SECTION 4.55(1A) MODIFICATION APPLICATION – SSD 11564741 STAGE 1B (STAGE 5) SUBDIVISION, BARANGAROO SOUTH

This modification application has been prepared by Ethos Urban on behalf of Lendlease (Millers Point) Pty Ltd (Lendlease), pursuant to section 4.55(1A) of the *Environmental Planning and Assessment Act 1979* (EP&A Act) to modify Development Consent SSD 11564741 relating to the stratum subdivision of Stage 1B (Stage 5) at Barangaroo South (the site).

PLAN OF PROPOSED SUBDIVISION
BASEMENT LEVEL 1
DATED: 1-8-2019
REV:04

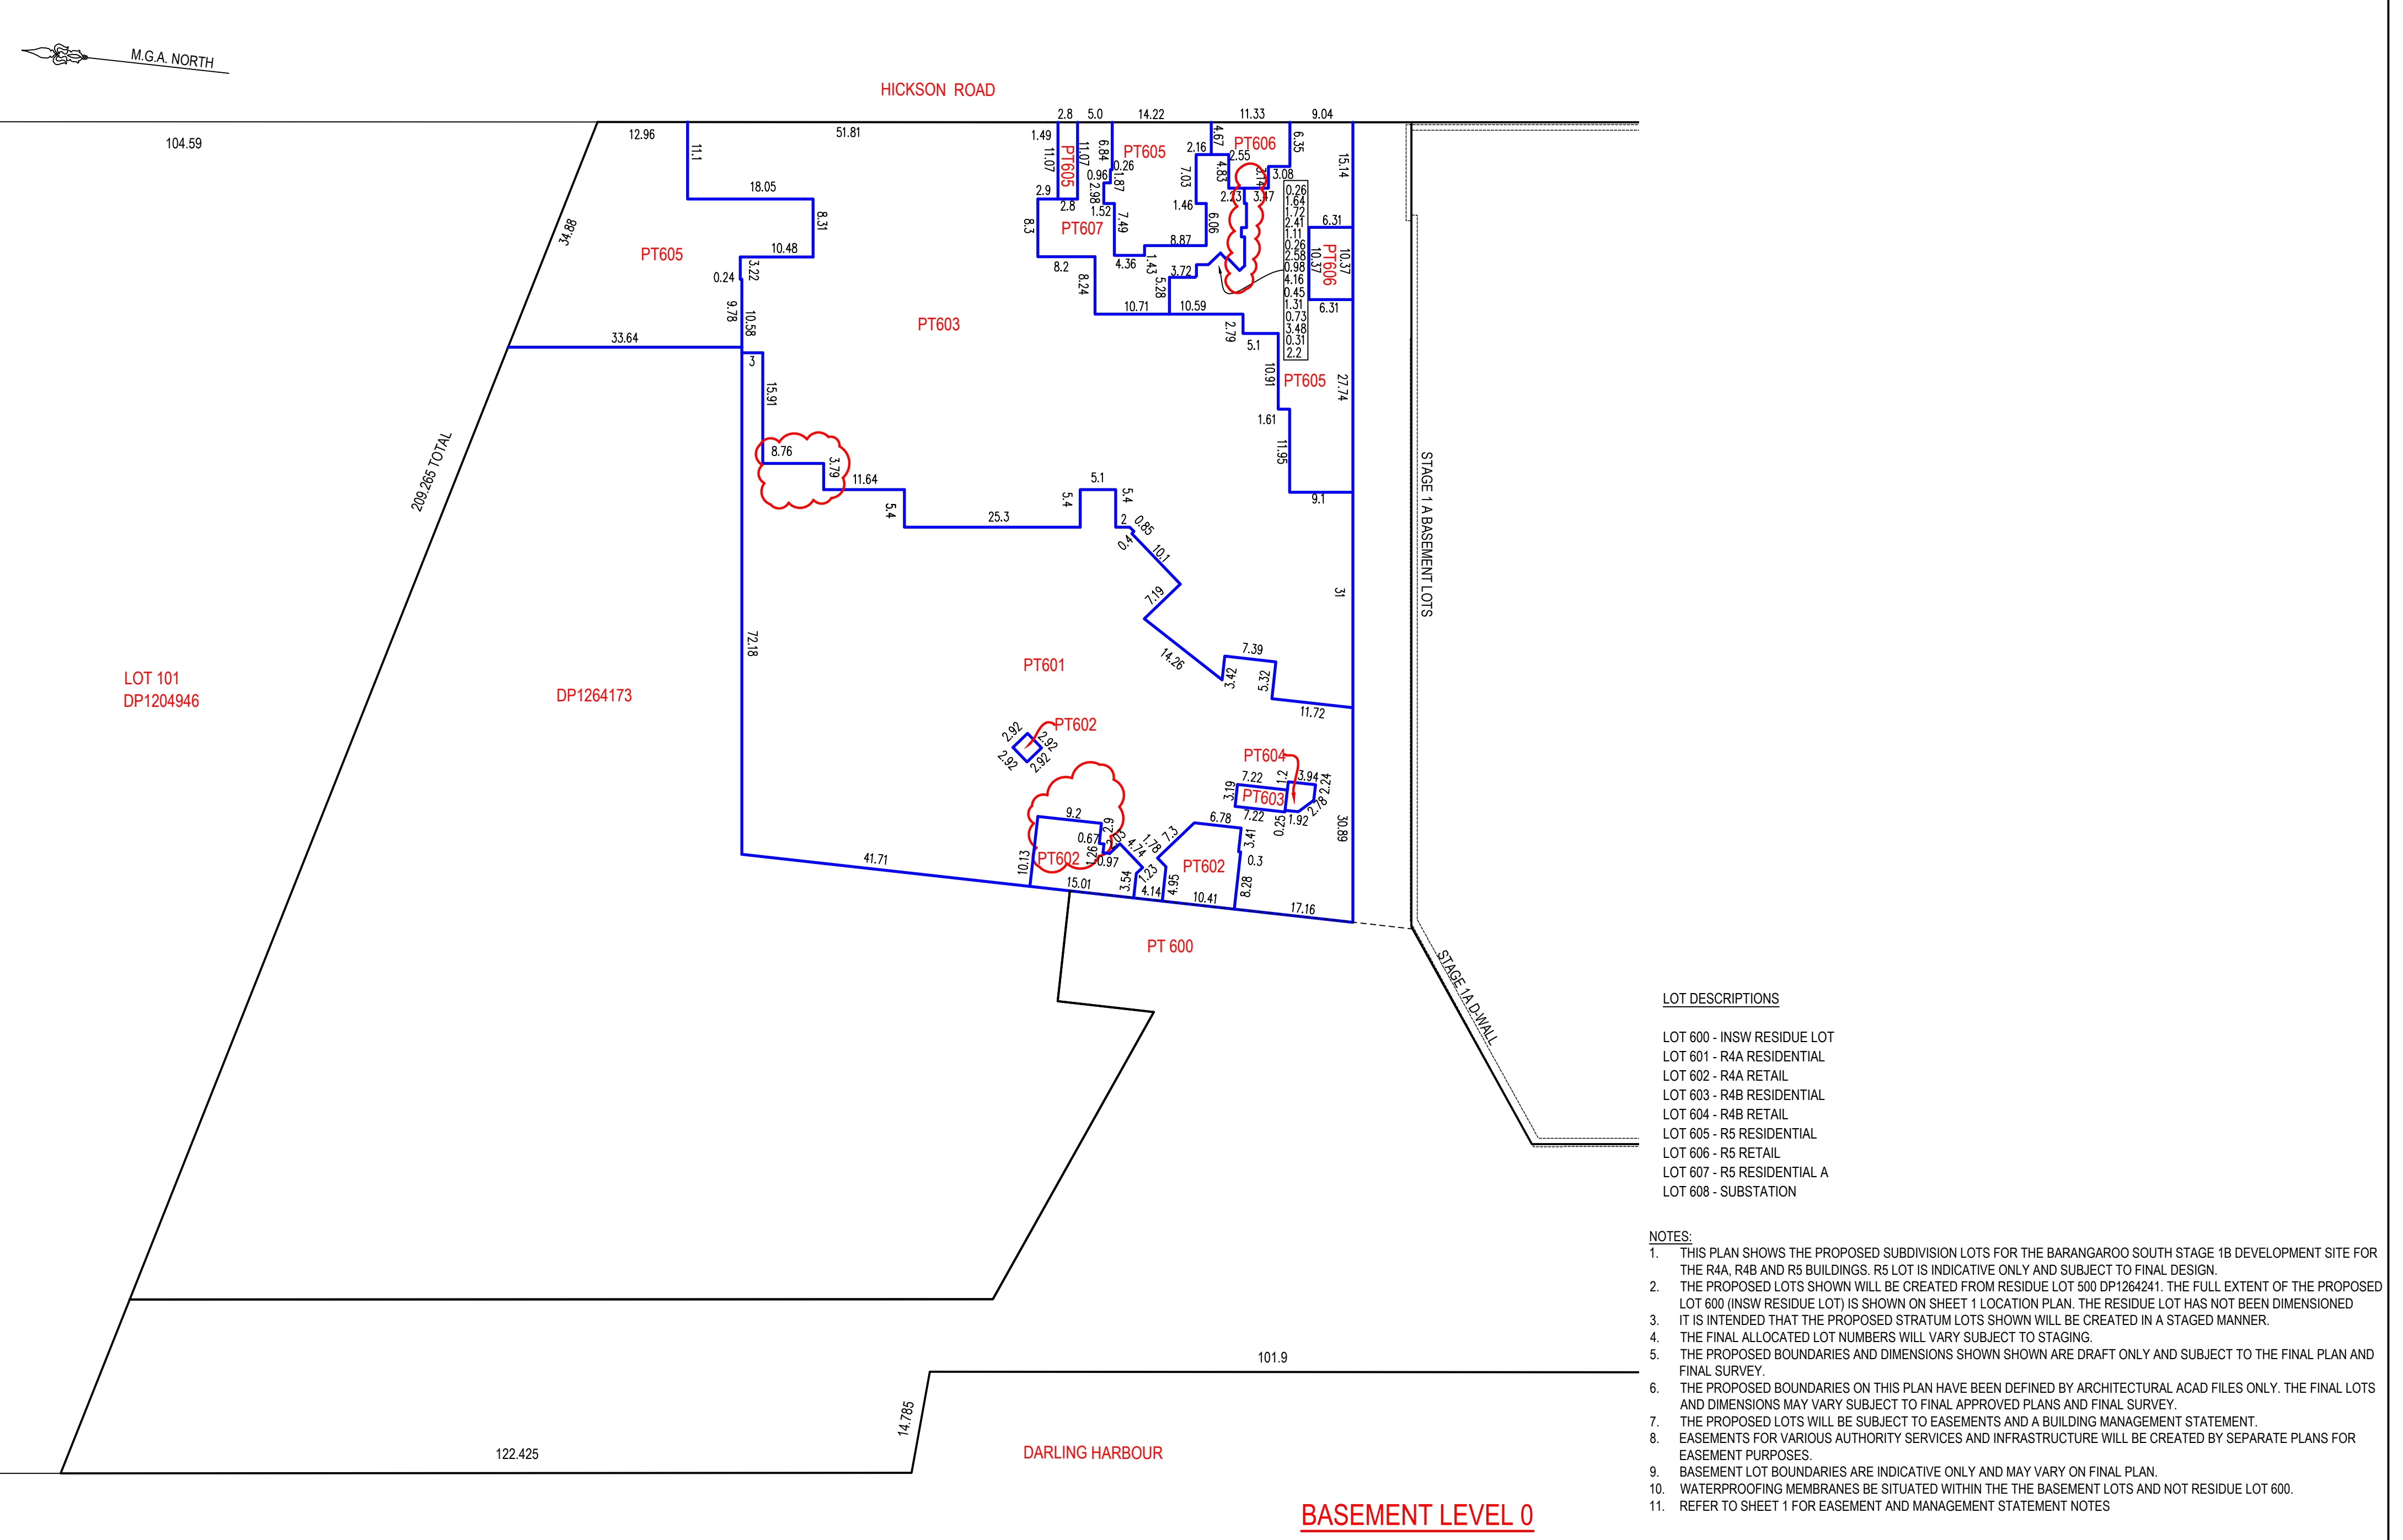
Lot number / location		
Stratum lot boundaries between Lot 605 and Lot 607 (in addition, 601 and 602, 601 and 603 as discussed below).	To reflect the proposed changes on Basement Level B0 being wall alignment, loading dock, storage and retail amenities (sought under separate modification application to Stage 1B Basement and Building R4A).	
Stratum lot boundaries between Lot 601 and 602	To reflect the proposed changes on Basement Level B1 regarding storage and amenities areas (sought under separate modification applications to Building R4A).	
Stratum lot boundaries between Lots 601 and 603	To reflect the proposed changes on Basement Level B1 regarding loading dock and storage areas (sought under separate modification applications to Stage 1B Basement, and Buildings R4A and R4B).	
Stratum lot boundaries between Lots 605 and 607.	To reflect reallocation of car parking spaces on Basement Level B1 within Building R5 lots (parking areas approved under Building R5).

To reflect retail amenities on Basement Level B1 (area approved under Building R5).

- Amendment of the Stratum lot boundaries between Lots 601 and 602 to reflect the proposed changes on Basement Level B1 (storage and retail amenities areas sought under separate modification application to Building R4A).

- Amendment of the Stratum lot boundaries between Lots 601 and 603 to reflect the proposed changes on Basement Level B1 (loading dock and storage areas sought under separate modification applications to the Stage 1B Basement, Buildings R4A and R4B).

- Amendment of the Stratum lot boundaries between Lots 605 and 607 to reflect reallocation of car parking spaces on Basement Level B1 for within Building R5 lots (parking approved under Building R5).

- Amendment of the Stratum lot boundaries between 605 and 606 to reflect changes on Basement Level B1 for retail amenities (area approved under Building R5).

BASEMENT LEVEL 4

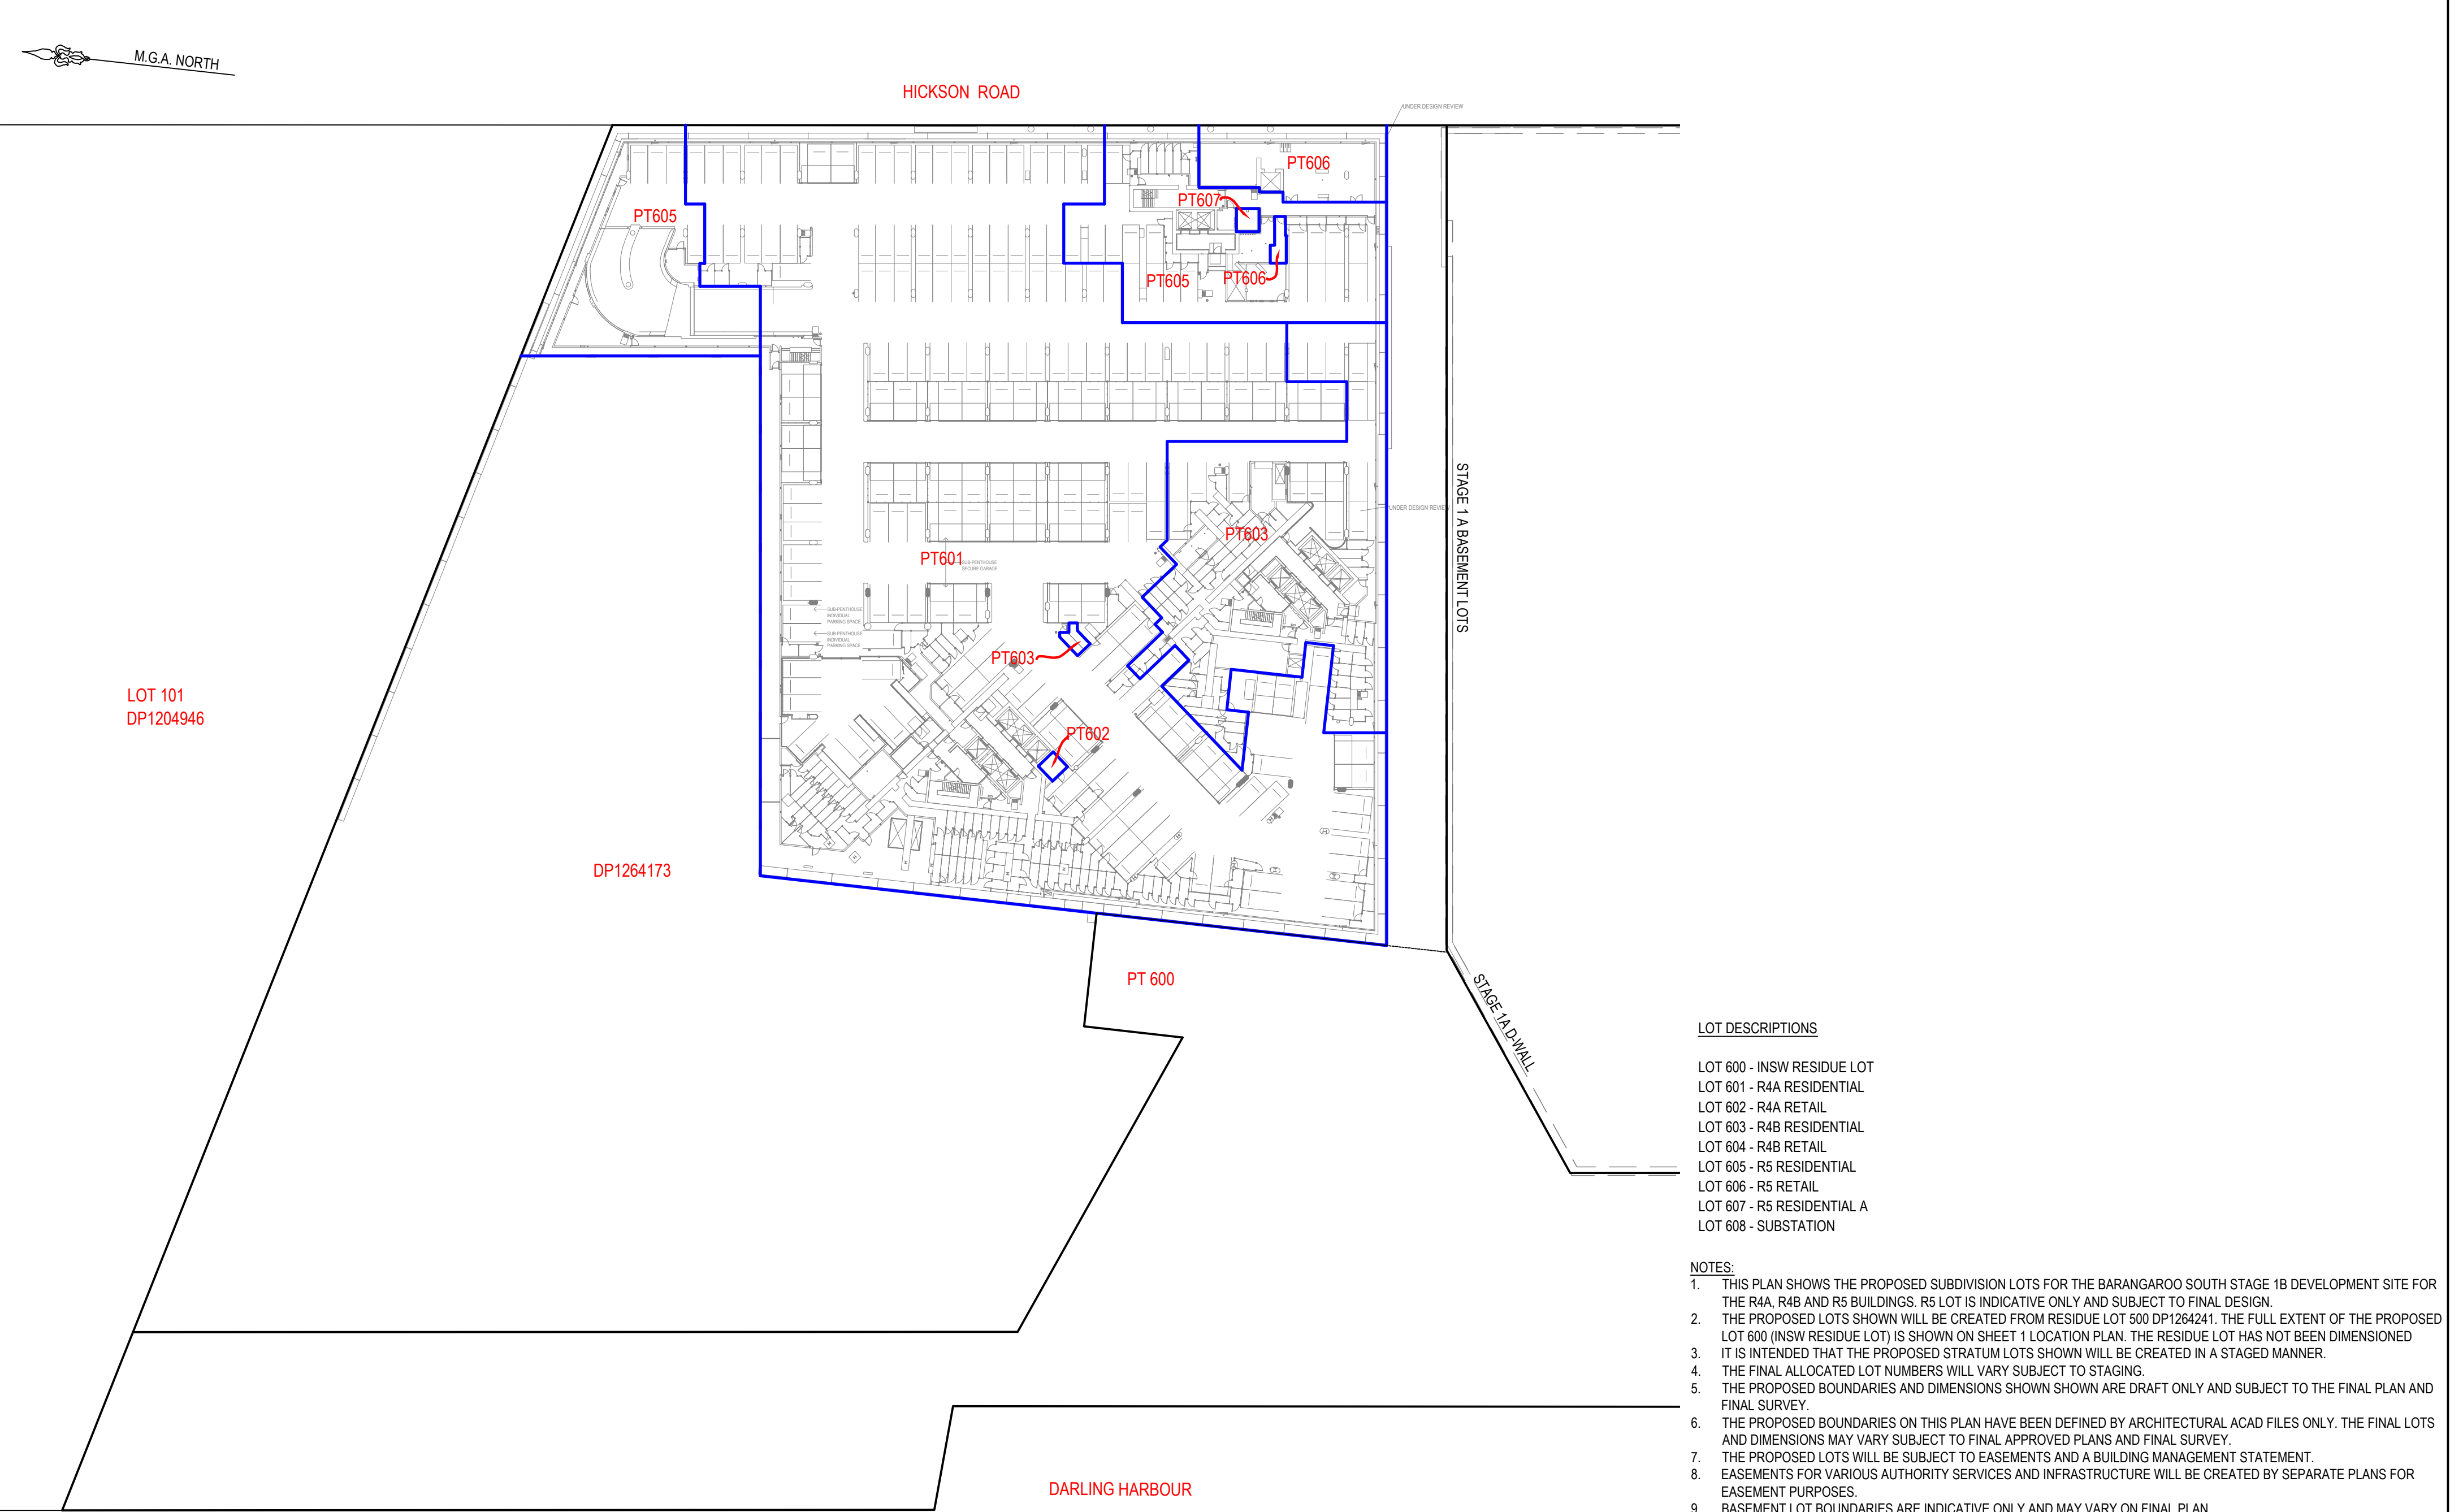
To reflect a proposed minor change to residential storage cage shape on Basement Level B4.

- Amendment of the Stratum lot boundaries between Lots 603 and 605 to reflect proposed changes on Basement Level B4 to an approved storage cage.
- Amendment of the Stratum lot boundaries between Lots 603 and 604 on the Ground Floor of Building R4B for retail amenities (area approved under Building R4B).
